AB/26/22/HH

45 Tarrant Street Arundel BN18 9DJ

Erection of garden room in rear and internal alterations.

client	project	drawing	date	drawn	drawing no	revision
Chris Thornton	New Garden Room & En-suite at The Old Brewery, 45-47 Tarrant St Arundel, BN18 9DJ	Proposed Floor Plans	Feb 22	pd	0364 / 103	-
			scale 1:50 @ A3	CAD file name:

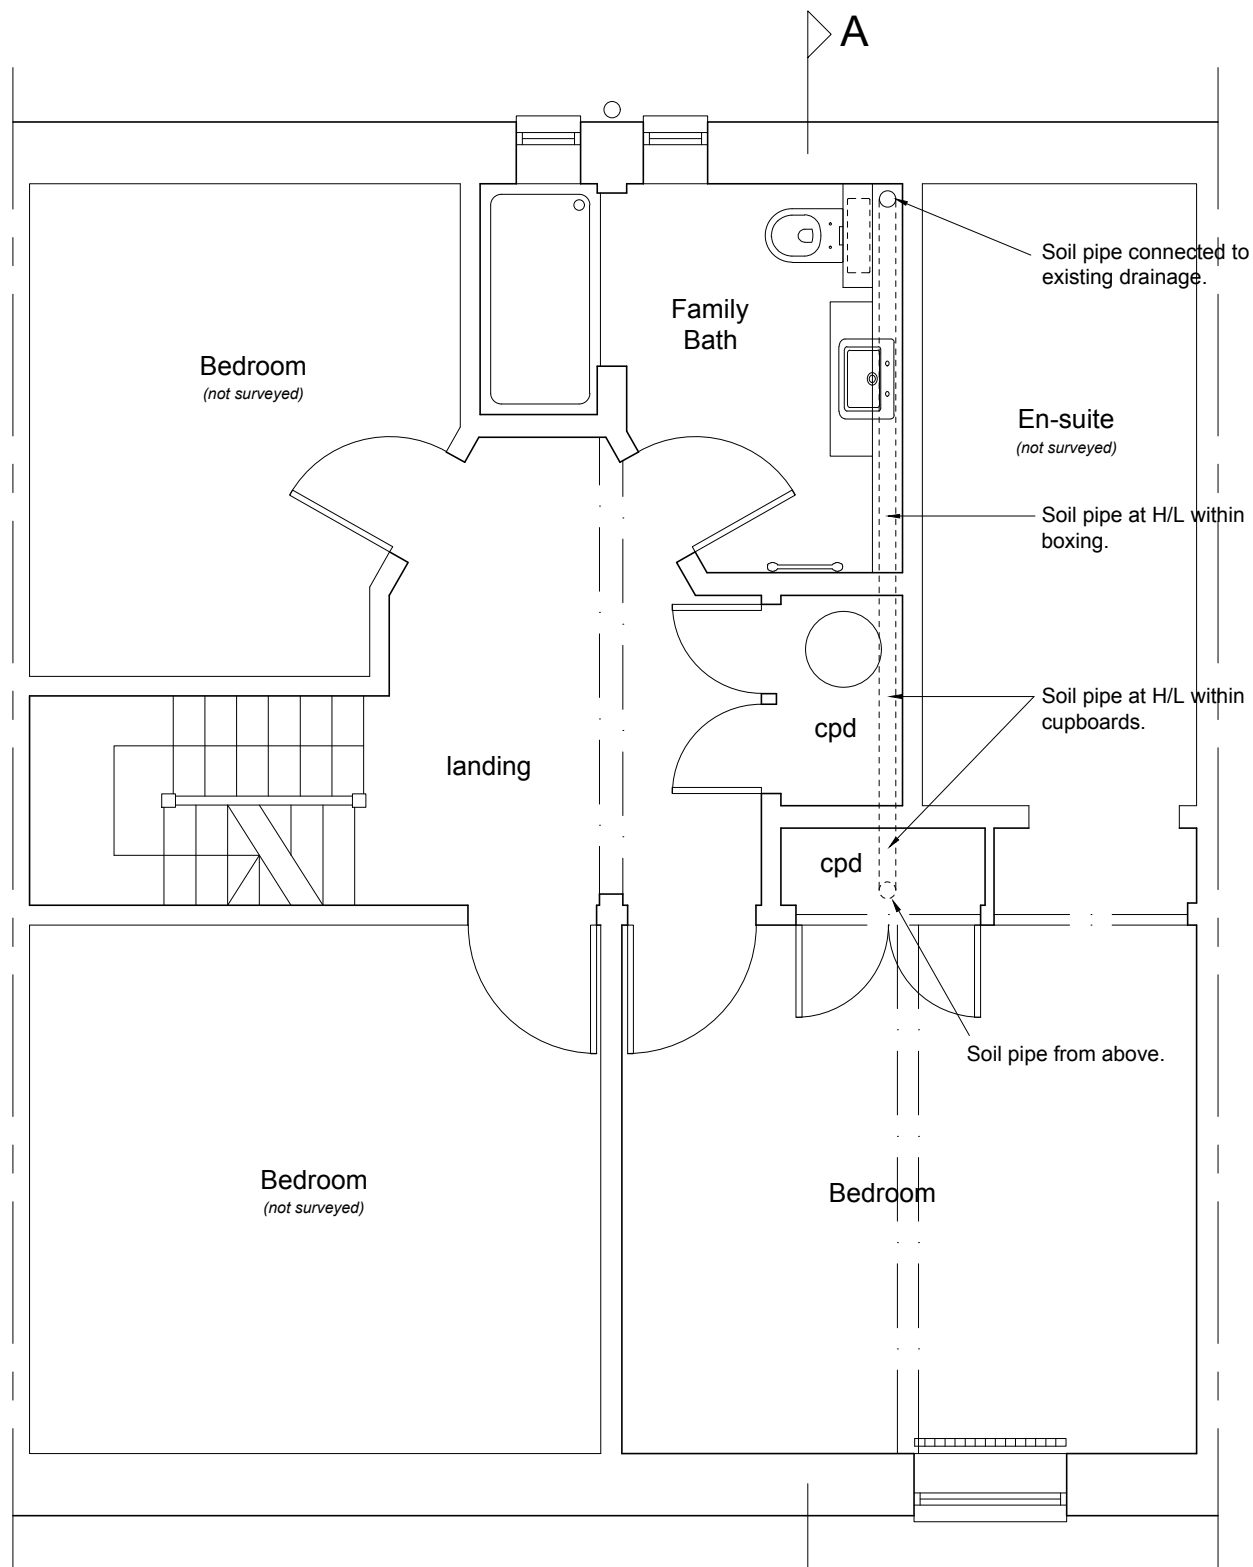
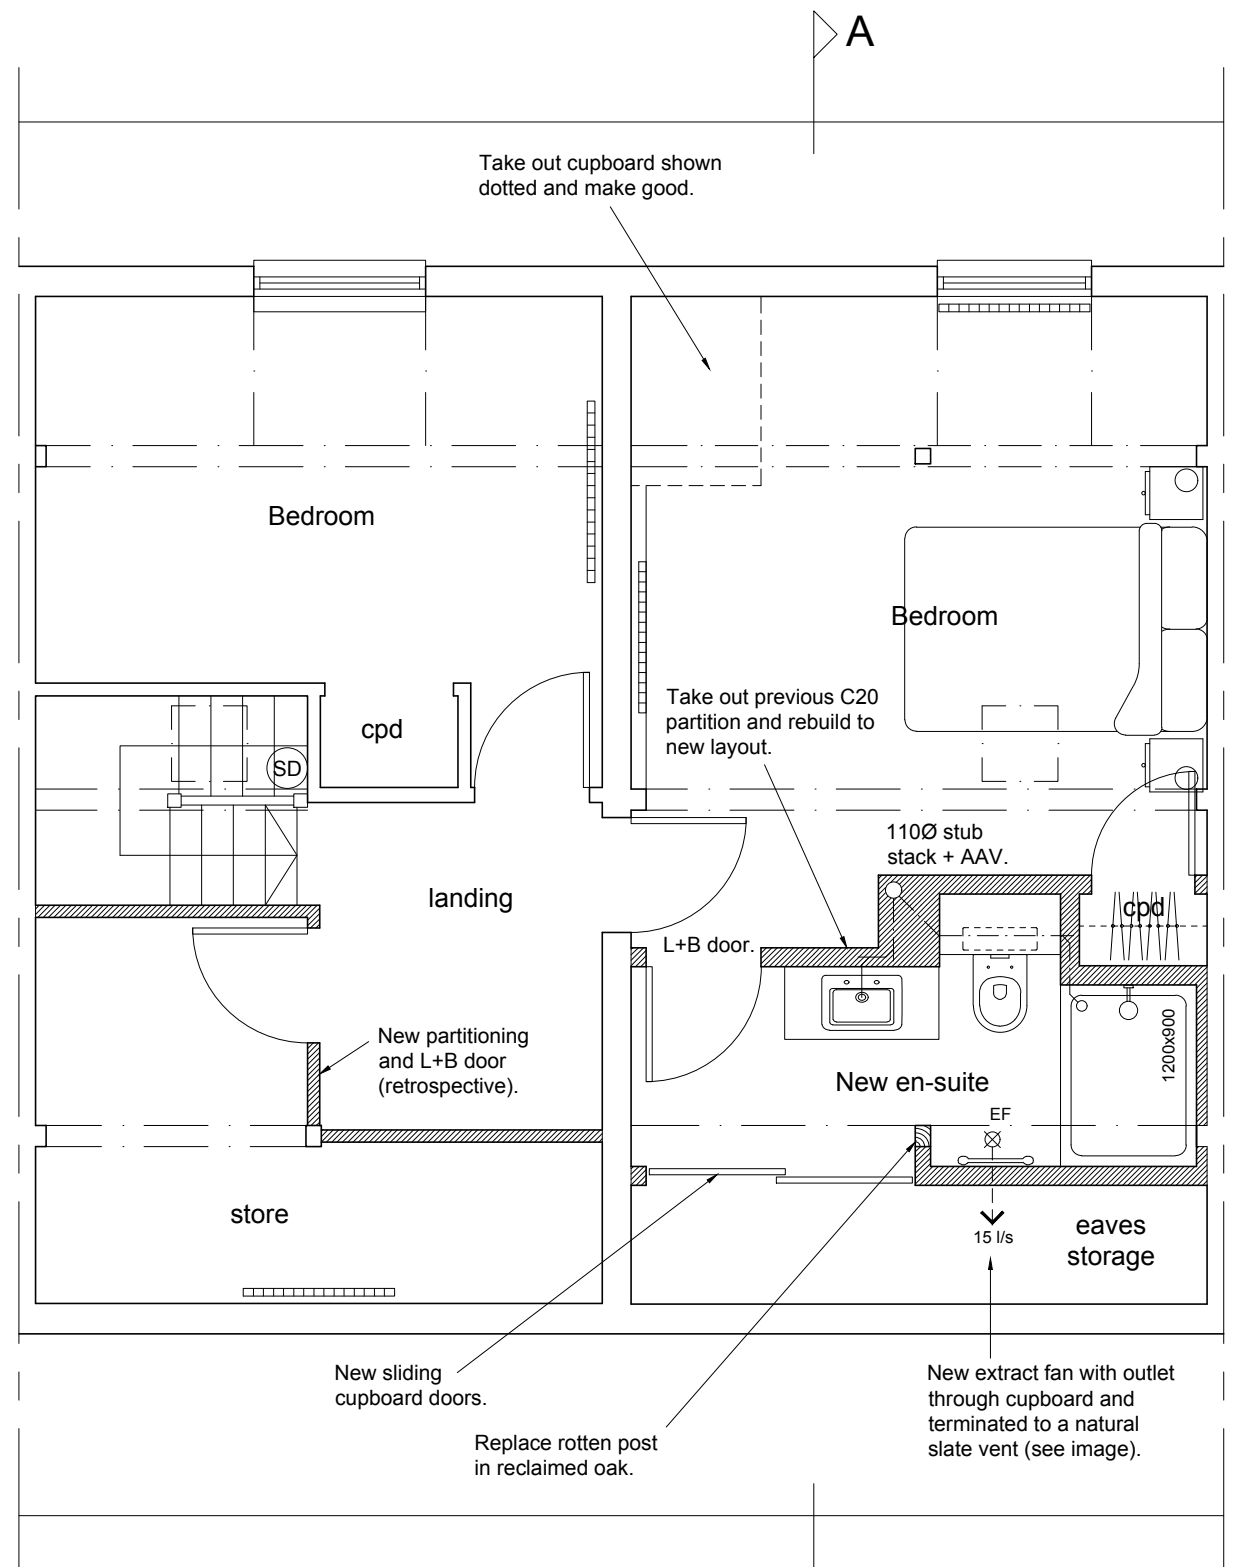
Internally, the proposal will include the removal of an existing wall and the insertion of a new one. I note that the proposed floor plans indicate that this partition is of C20 date, which would mean that it is of little or no significance. Its removal would therefore be acceptable. The creation of an additional bathroom would seem to be acceptable, and it appears that careful thought has been given to the issue of drainage. On balance, this element seems to be acceptable. I would want for any joinery (skirting etc) to match the existing and note that the doors will replicate the new one provided for the store.

I also note that part of the internal works have already been implemented without consent first being sought. This is disappointing, but at least consent is now being rectified. It is not clear what the previous floor plan consisted of as the both the existing and proposed floor plans look to be the same for this element of the application. However, that aside, the layout would appear to be acceptable and can be supported. As with all cases, it should be stressed that consent should be received prior to undertaking the works.

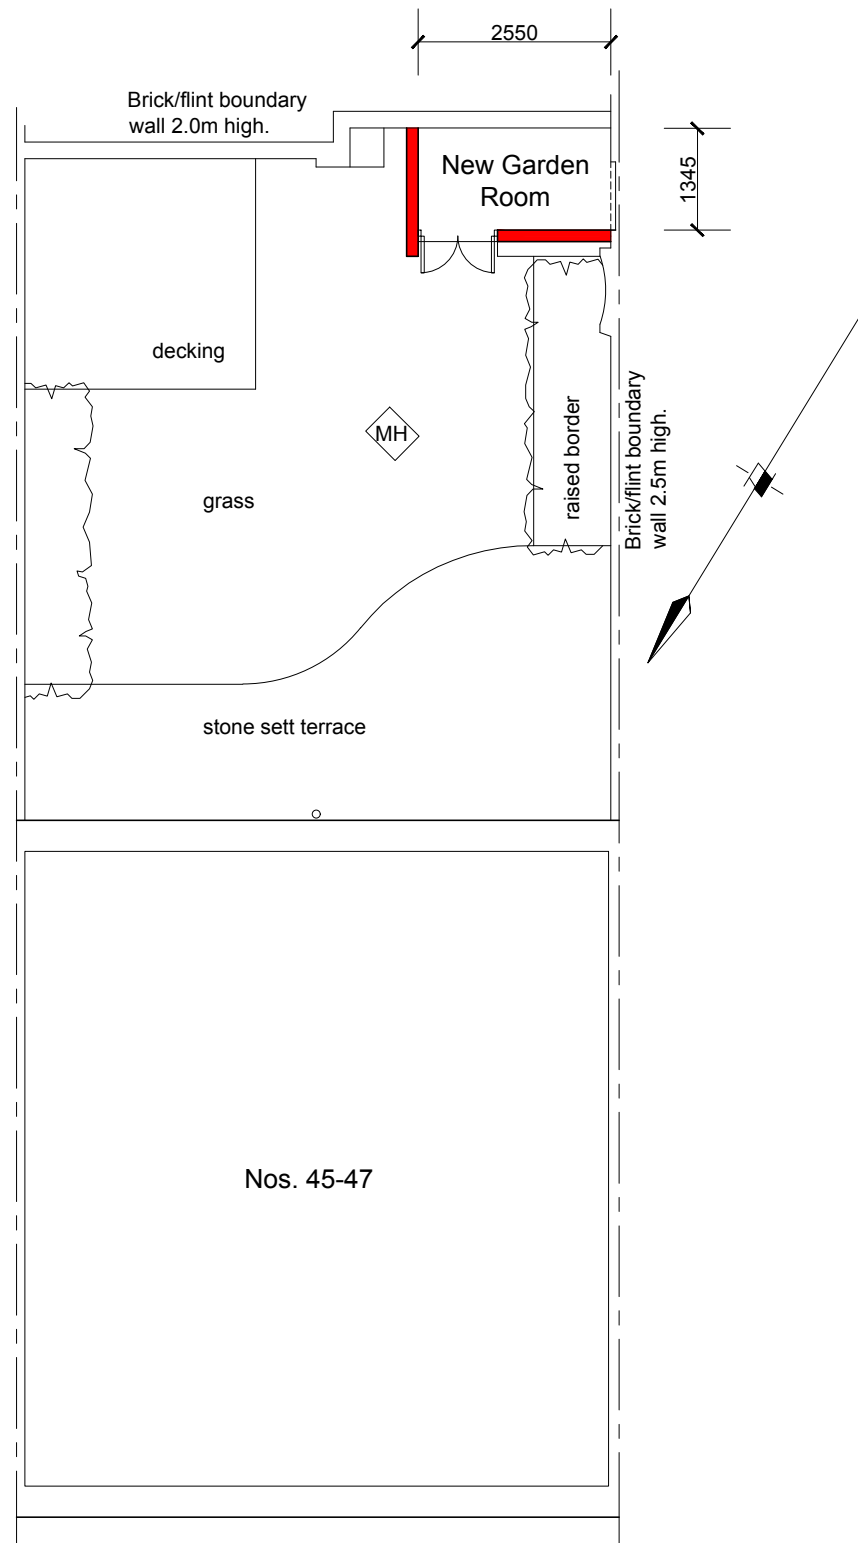
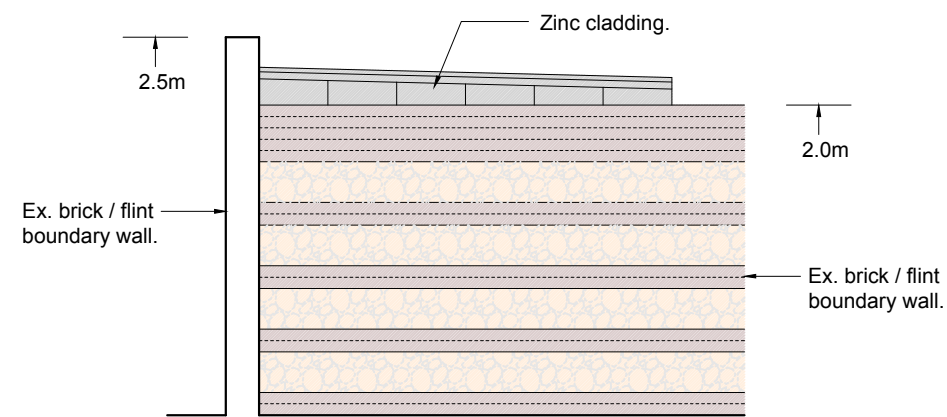
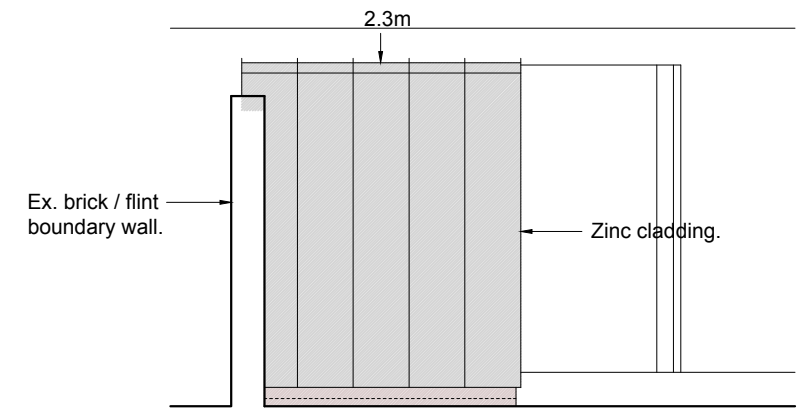
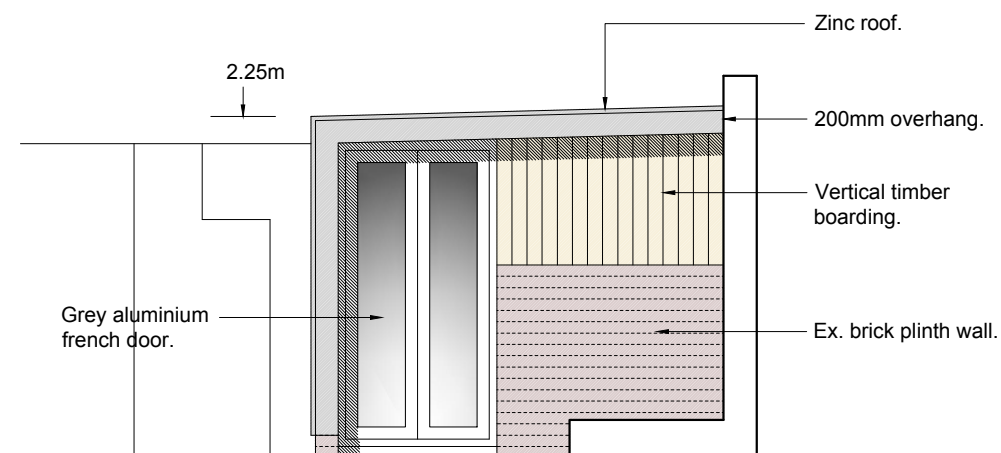
The new garden room is a small structure that takes advantage of some existing brick / flint walling, whilst also incorporating some elements of modern fabric. The design and additional materials such as the zinc all seem to be acceptable and will not cause harm.

It is positive to note in the method statement that the mortar for re-bedding and repointing will comprise lime with well-graded sharp sand to manufacturers recommendations. The finished colour of the mortar will depend upon the sand used and samples must be prepared to ensure a good colour match to the existing mortar it replaces.
